Response to Planning application from Hertfordshire County Council (T and CP GDP Order 2015)

District ref: 6/2021/2260/FULL
HCC ref: WH/8633/2021
HCC received: 23 August 2021
Area manager: Matthew Armstrong
Case officer: Samuel Tearle

SHELL WELWYN GARDEN CITY STANBOROUGH ROAD WELWYN GARDEN CITY AL8 6XA

Proposal

PROPOSED ACCESSES  
 & PEDESTRIAN CROSSING  
 POINTS

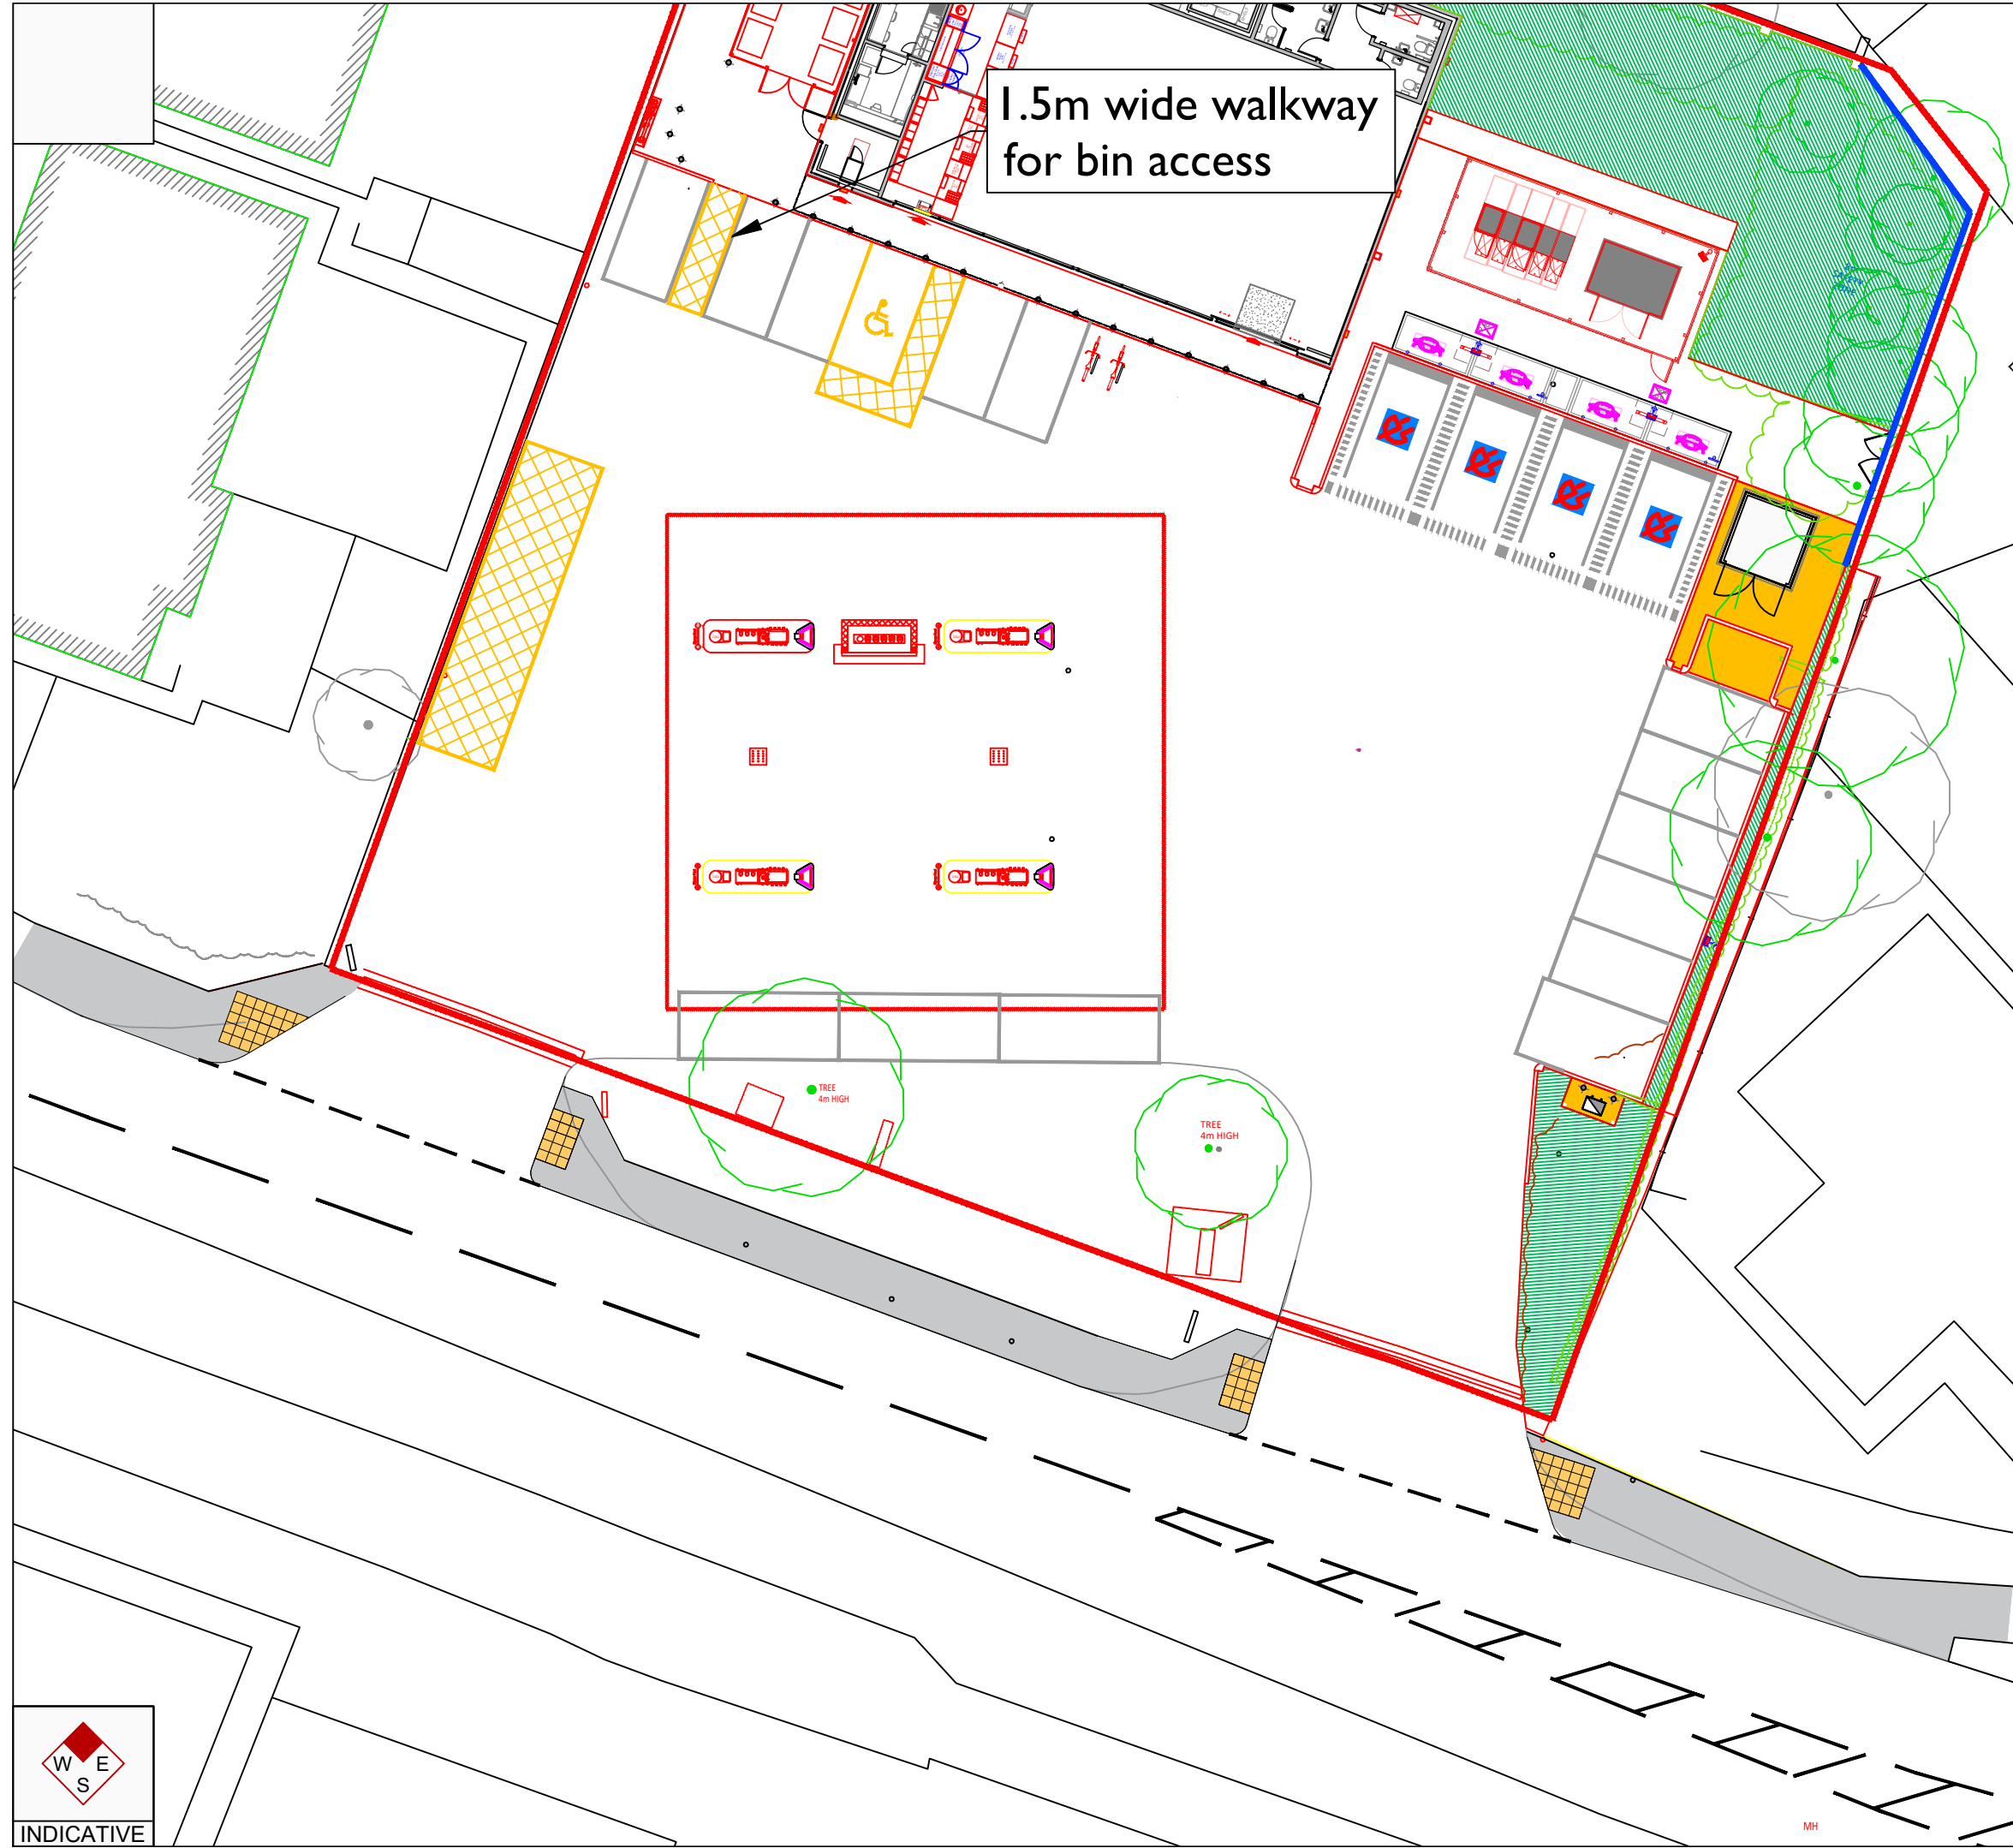
The existing vehicular accesses are in the form of wide bellmouths that are considered by the Highway Authority to be unsuitable to support pedestrian movements of all ages and abilities and represent a safety risk due to excessive crossing distances and also allows vehicles to enter and exit the site at speed.

As the current proposals are to retain the separate 'entry' and 'exit' only arrangements, it is requested that the accesses are narrowed, and footways extended to include dropped kerbs and tactile paving or a footway crossover arrangement. This will encourage vehicles to travel at lower speeds when entering and exiting the site and will support pedestrian movements of all ages and abilities.

TITLE:  
**Swept path analysis  
of proposed site layout**

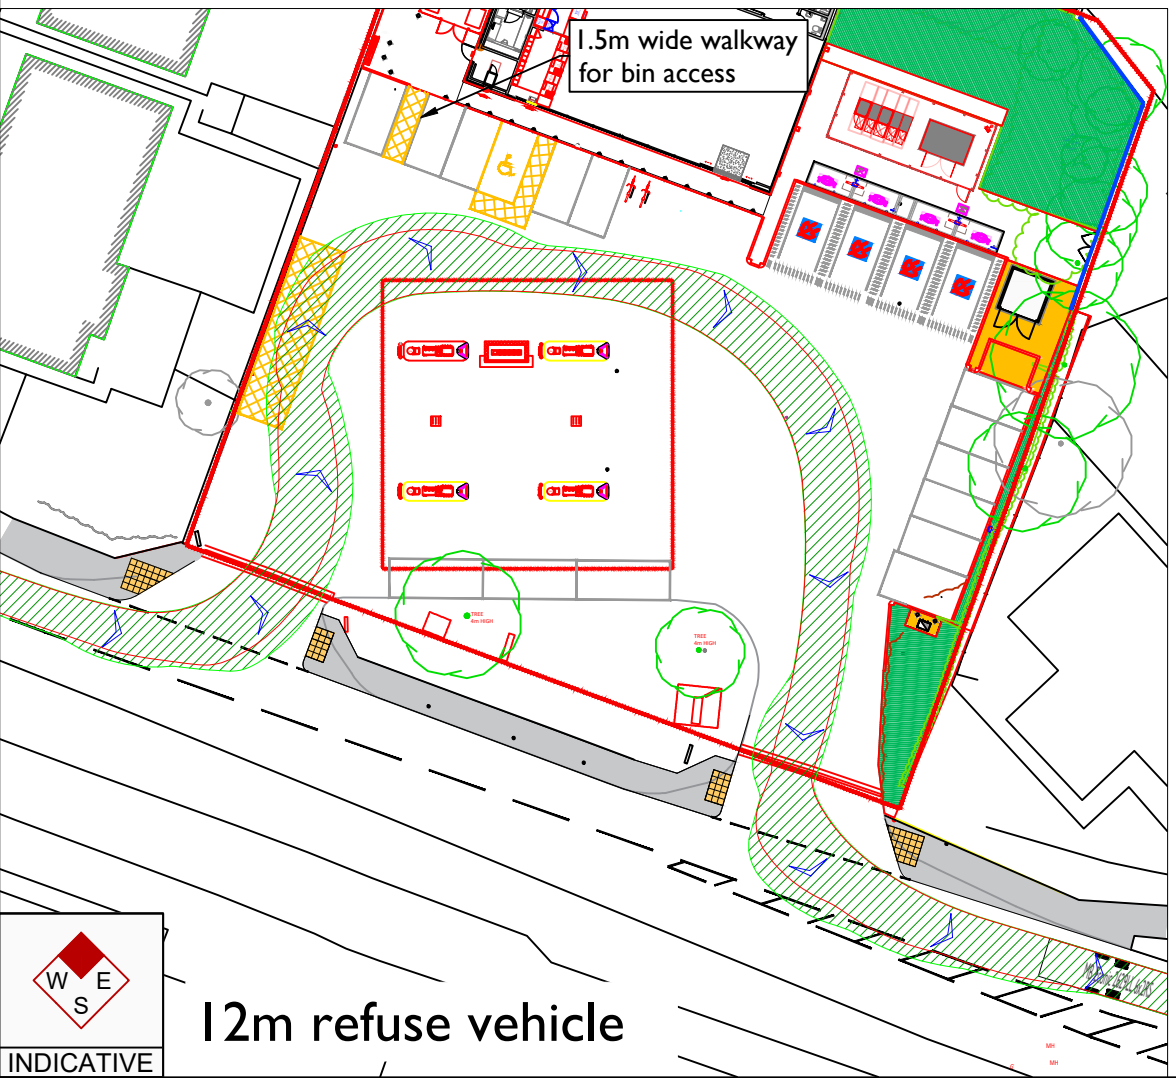
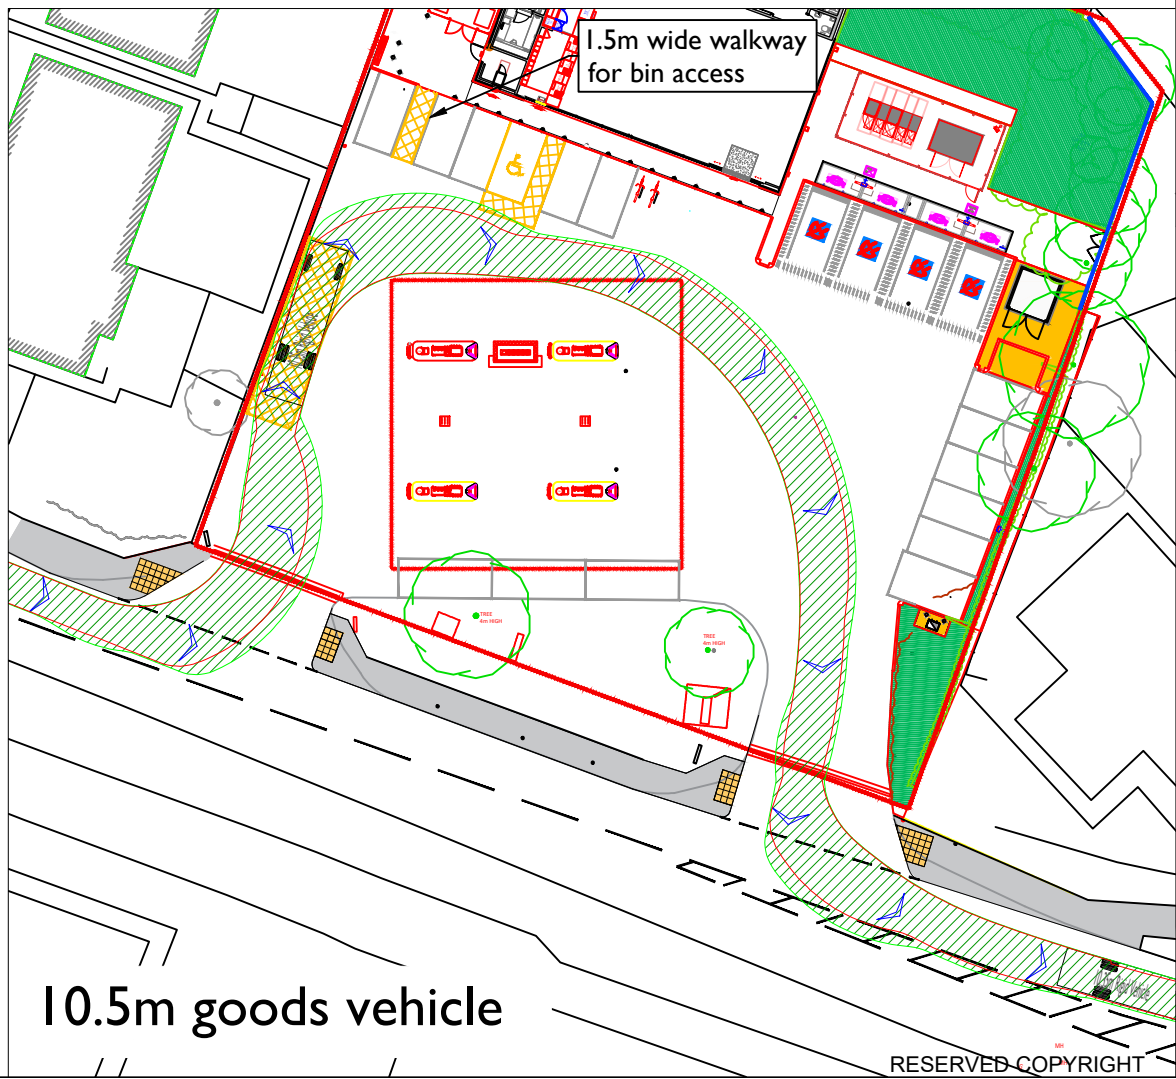
When vehicles are parked in the proposed spaces, alongside the bollards, it is unclear how a refuse collector will be able to drag the bins to the refuse collection vehicle. It is also unclear whether a refuse collection vehicle will reverse out of the entry only access or use the proposed separate entry and exit junctions. The Highway Authority only consider the latter arrangement to be acceptable and a swept path analysis drawing must be submitted to demonstrate it is achievable.

The servicing arrangements for the proposed development have not been detailed. It is noted the Proposed Site Layout Drawing No. 12038629_PSL2_21 includes a delivery bay on the west of the site, however it is unclear whether a delivery vehicle or fuel tanker will reverse out of the entry only access or use the proposed separate entry and exit junctions. The Highway Authority only consider the latter arrangement to be acceptable and a swept path analysis drawing must be submitted to demonstrate it is achievable.

DWG No:	12038629	PSL2	21
---------	----------	------	----

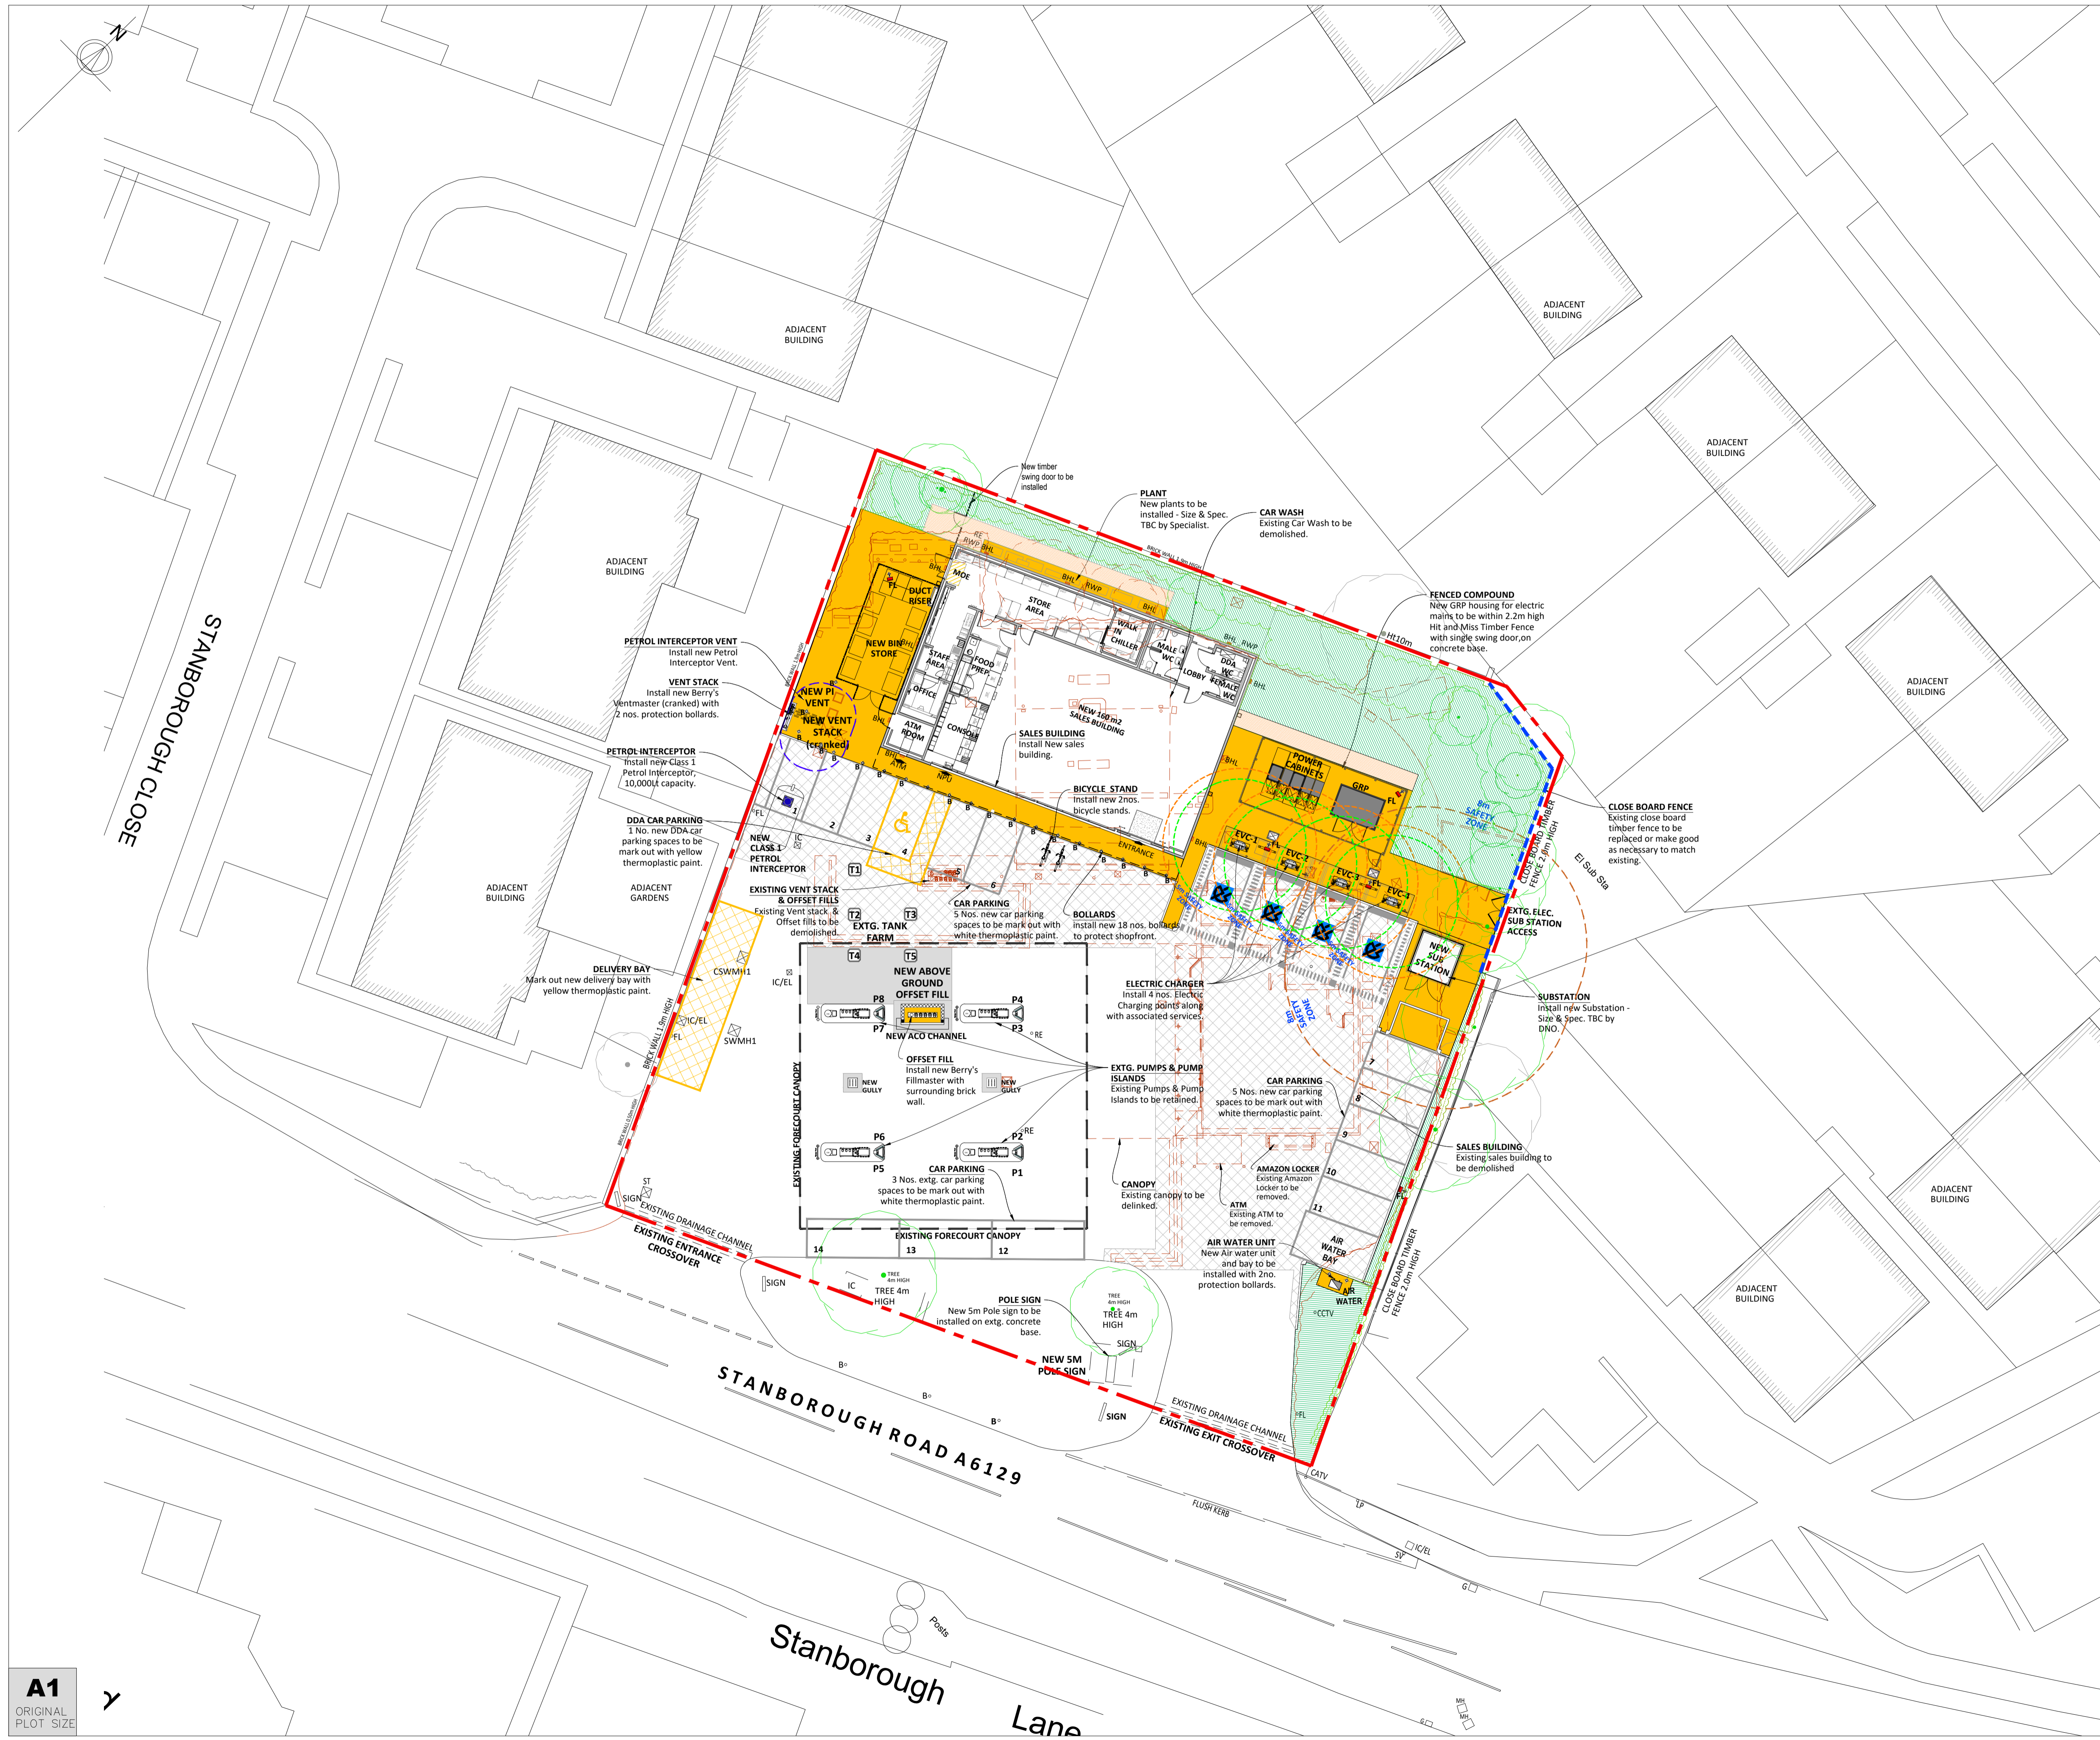
The proposals, as shown on the Proposed Site Layout Drawing No. 12038629_PSL2_21 include a bin store on the north west of the site. Opposite the bin store is a row of perpendicular car parking spaces and bollards.

The proposals, as shown on the Proposed Site Layout Drawing No. 12038629_PSL2_21 include the provision of 14 car parking spaces (including one disabled spaces) and four EV charging spaces. The proposals also include two cycle parking stands located near the entrance of the store. The Highway Authority are satisfied with this arrangement.

It is noted that the Application Form states there will be 11 car parking spaces. The disparity should be clarified.

The proposals, as shown on the Proposed Site Layout Drawing No. 12038629_PSL2_21, include two signs located outside of the site's red line boundary. Therefore, if the application is approved a licence will be required and details will be provided by way of an informative.
